APPLICATION NO: 24/00049/FUL/ADDINF

DESCRIPTION: Proposed garage conversion into a bedroom with bathroom facility.

LOCATION: 38 Gloucestershire Lea Warfield Bracknell

Site Plan 1:500

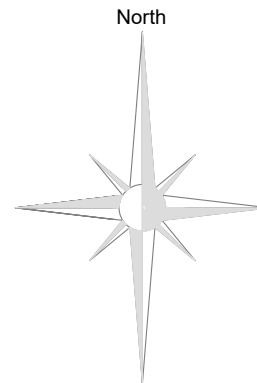
- 1 Standard parking spaces for a three-bedroom house are two. As you are converting the garage into habitable accommodation, we require a parking plan.
